**KIRKLEES METROPOLITAN COUNCIL
INVESTMENT & REGENERATION SERVICE**

Reference no. 2023/CL/91579/W

**Thornton And Ross Ltd,
Manchester Road, Linthwaite,
Huddersfield, HD7 5QH**

**Prior notification for installation of
roof mounted solar photovoltaic
equipment**

TITLE:
Location of Proposed Solar
Array

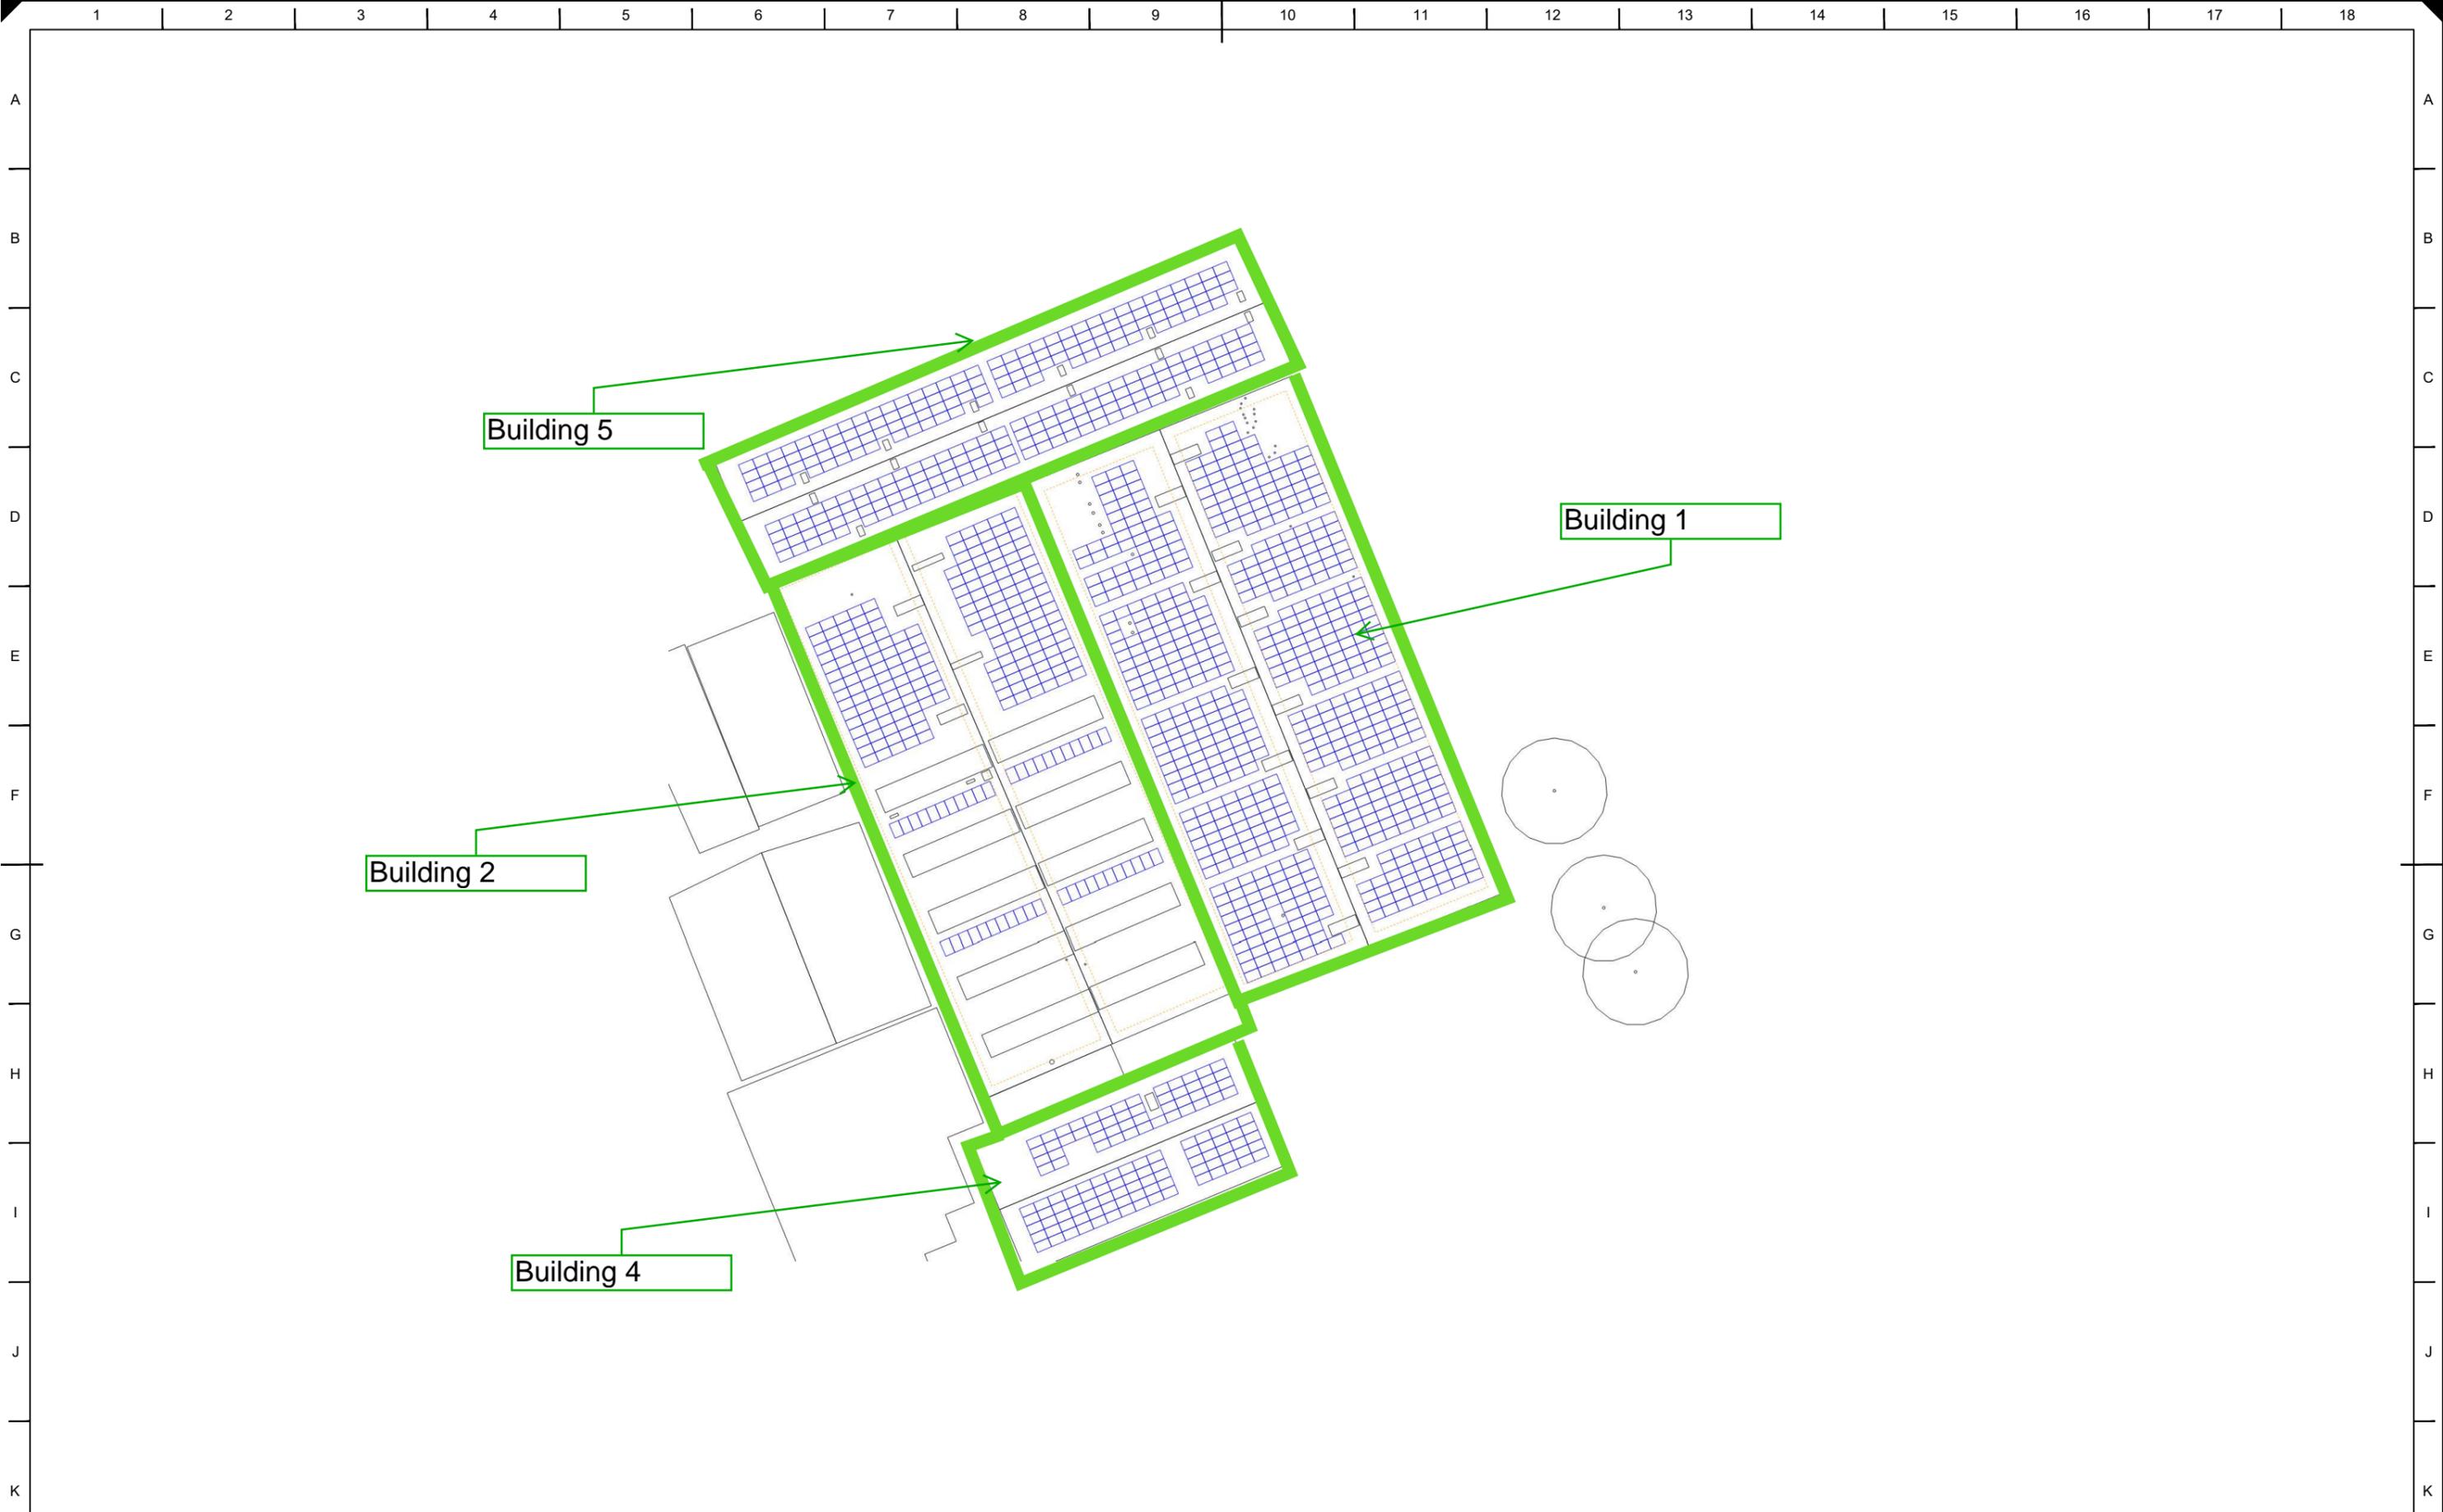
The solar panels would be located on the roof planes of 4 no. buildings within the site which are clearly demonstrated on plan. Each building would host a number of panels which vary in terms of the number of panels.

Whilst there would be some contrast to the building roof materials, the panels would not consist of an unacceptable alteration to the building. The appearance of the building would not be harmed by the introduction of PV panels and as such, acceptable within the street scene.

The building is low rise and hosts pitched roof forms with the proposed panels visible from public vantage points. The submitted information does not conclude whether or not the panels will be anti-glare and therefore an appropriate condition can be added to the decision notice to ensure that the amenity of neighbouring residential properties can be protected.

The solar panels hereby approved shall be installed with anti-reflective glass panels and retained as such thereafter.
